**To:** FILE  
**From:** Nell Donaldson  
**Subject:** Application ID: 2013-245  
**Date:** 11/19/2013

Memo To: Nell Donaldson  
Barbara Barhydt  
From: David Margolis-Pineo  
Re: 46 Market Street

I-7A

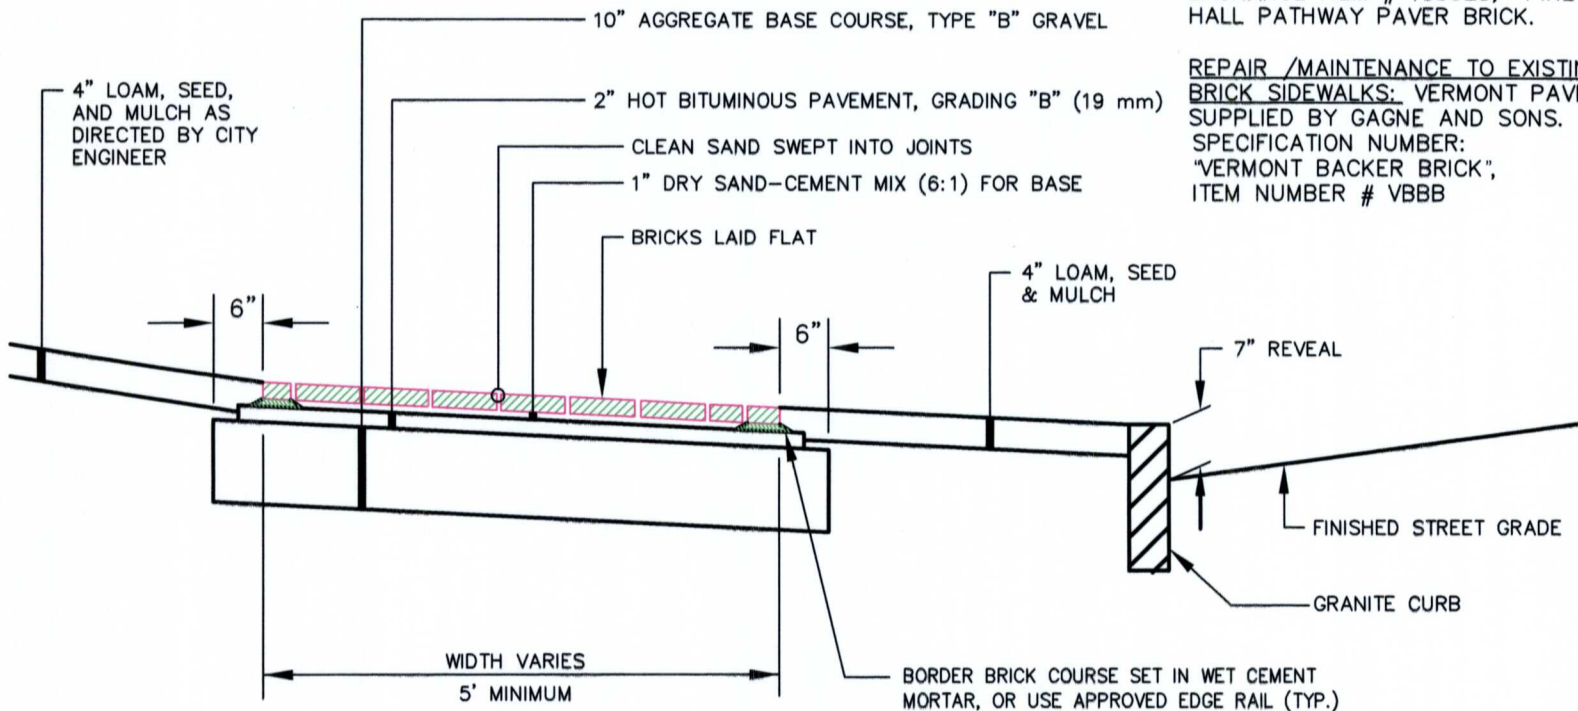
1. The applicant is requested to re-build the sidewalk ramp at the corner of Milk and Market Streets installing a detectable warning panel for the historic district per Figure I-7A on page 40 of the City's Technical Manual. The applicant is also request to install a short section of flush granite curb in conjunction with this ramp. The City may have a piece of granite curbing stored on outer Congress St which may be used at no cost to the applicant except to pick up and transport. The applicant is requested to use the Pinehall Pathway Pavers bricks when rebuilding this ramp.
